Please ask for: Ms Iqraa Malik
Email: iqraa.malik@terraquest.co.uk
Telephone: 01212341390
Our Ref: AB/75/21/HH
Your Ref:
Date: 14th June 2021

Application for Planning Permission for Works or Extension to a Dwelling

Location: 54 Tarrant Street Arundel BN18 9DN

I regret that I am unable to accept your documents as a valid application until the following item(s) have been received or resolved :-

SITE + LOCATION PLANS

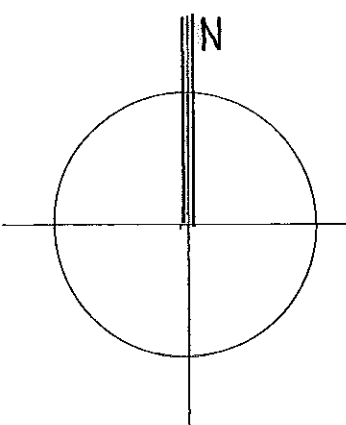
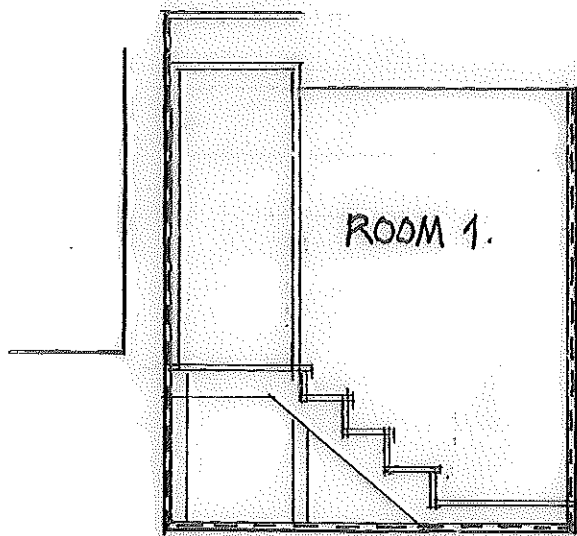
The location and block plan does not measure to scale. Please amend.
